Our ref: Q210286/EL
Your ref: PP-12108332
Email: lucas.fallon@quod.com
Date: 04.05.23

Axis J9, Phase 3 – Application for Non-Material Amendment

On behalf of Albion Land (“the Applicant”), please find enclosed an application for a non-material amendment to planning permission 21/03177/F at Axis J9 (“the Site”). The application seeks to vary the list of approved plans set out in Condition 2 to alter Unit 4’s loading door arrangements to accommodate the operations of tenants.

Drawing Title: **External Lighting Layout**

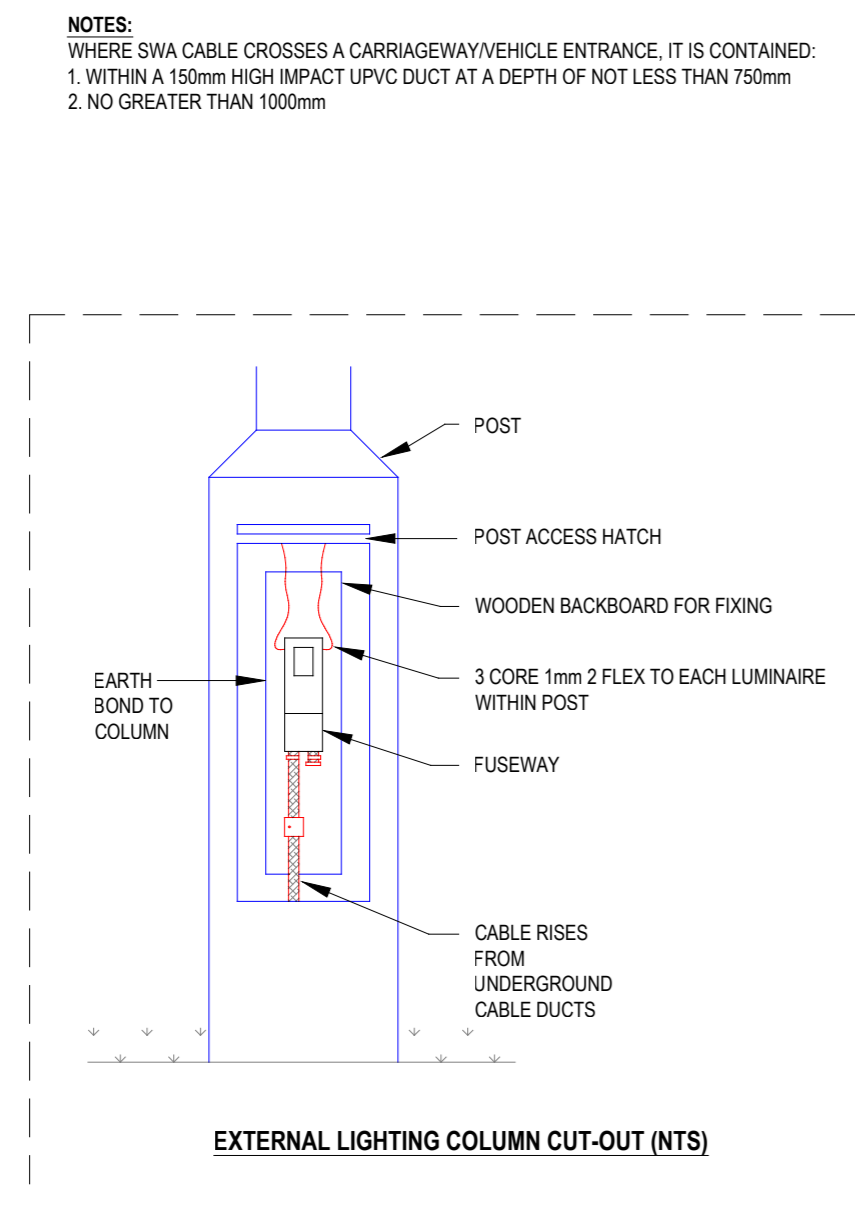
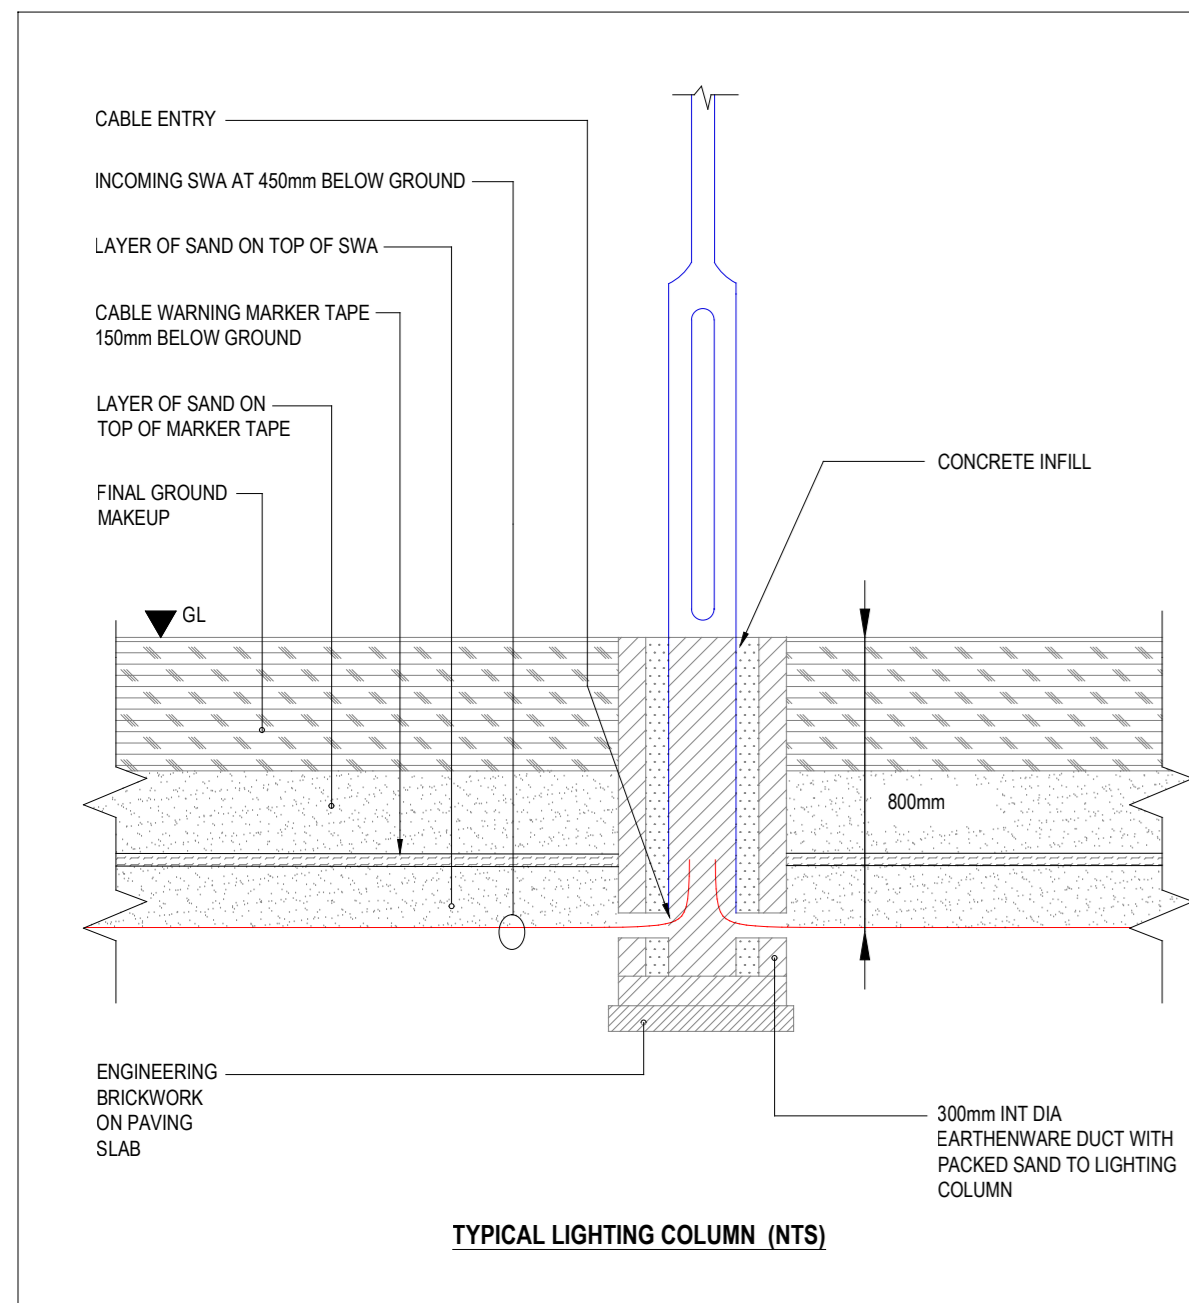
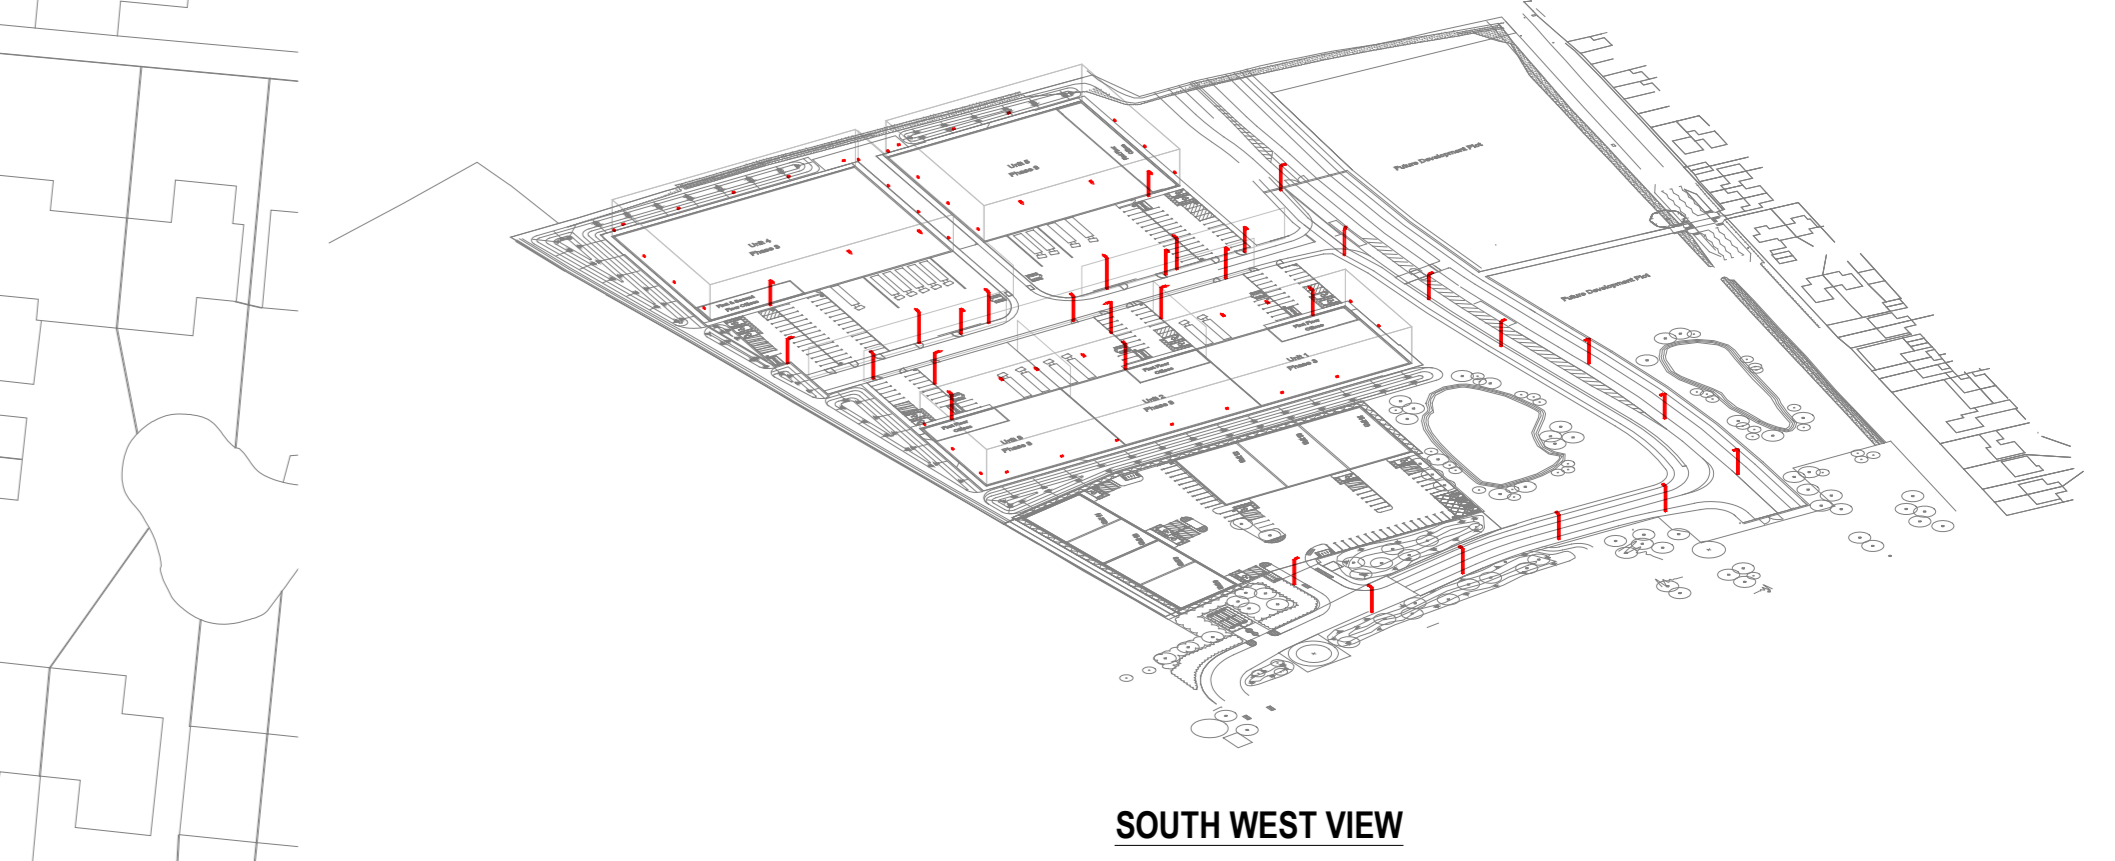
The enclosed 1746-ESC-00-ZZ-DR-E-2100 Rev P4 'External Lighting Layout' outlines the external lighting layout which has been amended from the previously consented 1746-ESC-00-ZZ-DR-E-2100 Rev P3 'External Lighting Layout' to be consistent with the proposed new layout and taking account of the alterations to the loading arrangements above.
